Address: The Inner Hey Manchester Road Huddersfield Hd7 6EL

Application number: 2023/92740	
What is the application for?:	Raise roof height to provide additional accommodation (within a Conservation Area)
Address of the site or building:	12, Inner Hey, Marsden, Huddersfield, HD7 6EL
Postcode:	HD7 6EL

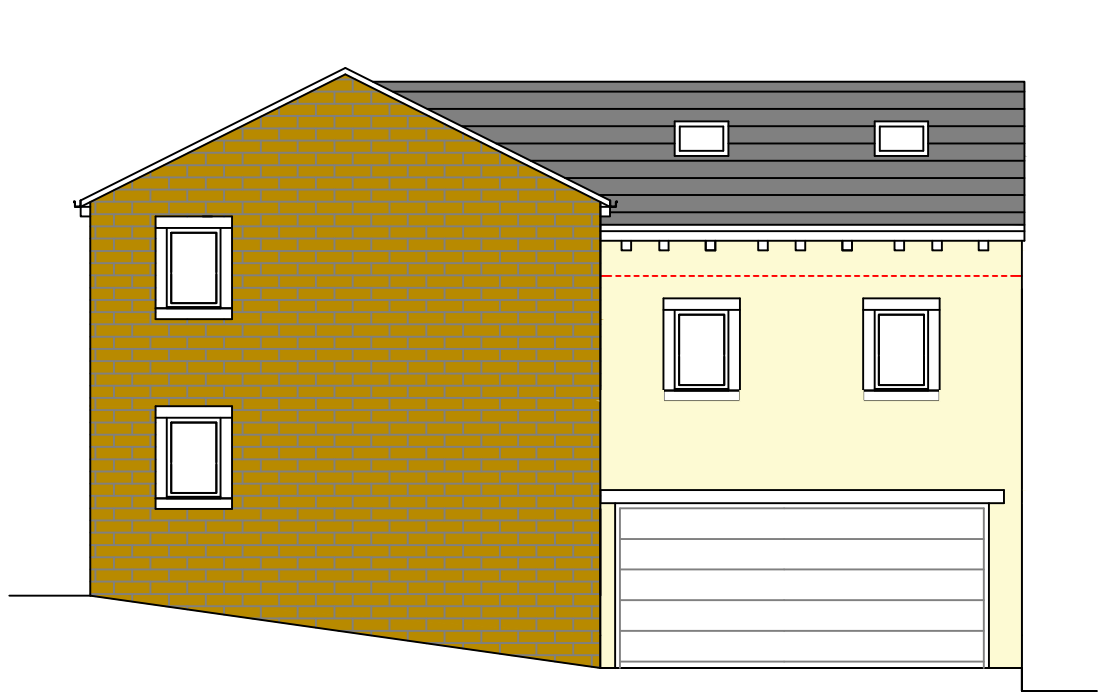
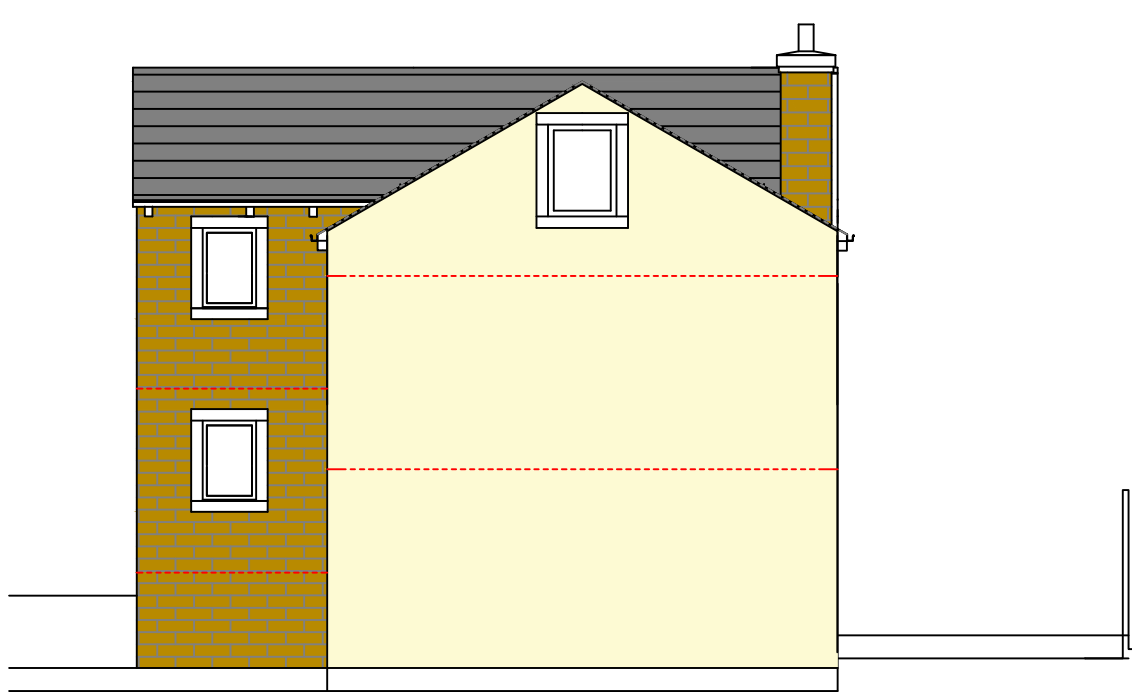
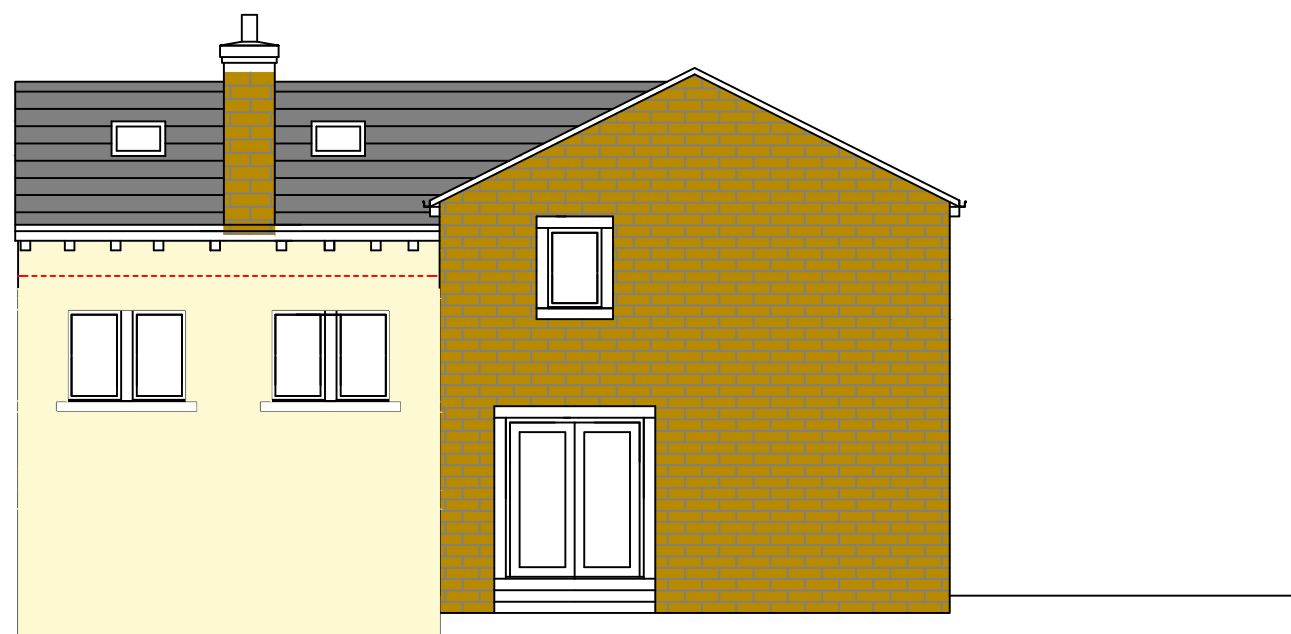
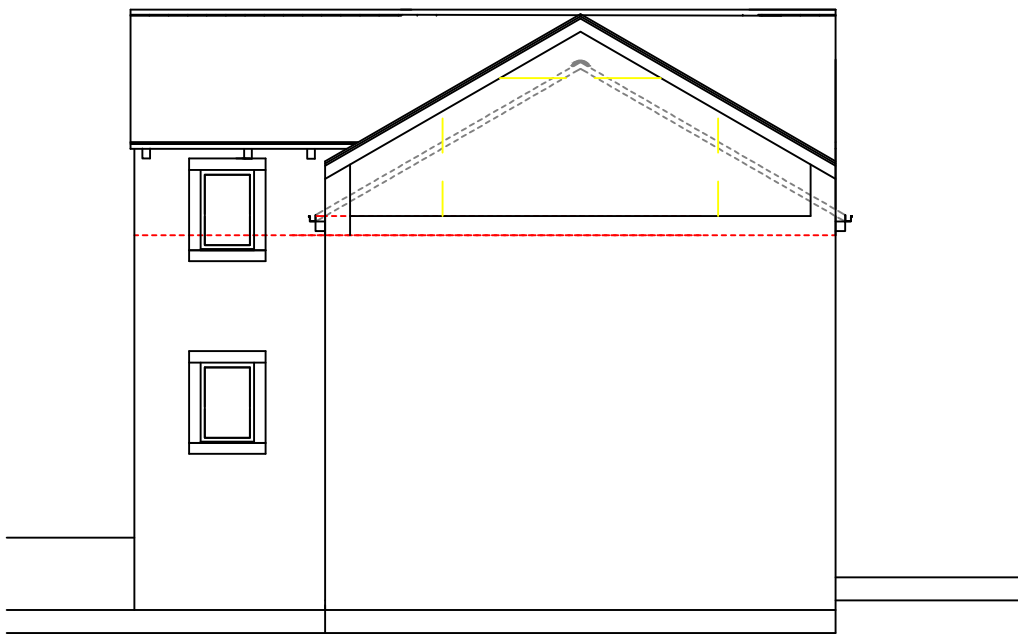
Type of comment: An objection	
Do you wish your comments to be published on the website anonymously?	No
<p>This is the third time this application has been submitted and materially nothing has changed. The raising of the roof height takes it above the roofline of the other buildings in the area which it was meant to have been built sympathetically alongside. The Inner Hey is a grade 2 listed building which it borders, The window in the end elevation still overlooks the Inner Hey side and rear garden. We already have a 10 ft fence that attempts to prevent the garden being overlooked as the property was not built to the original plans. I don't believe any of the minor changes that are in this application have dealt with the planning issues raised in the decision document of the previous 2 applications and so don't see how this application can be considered.</p>
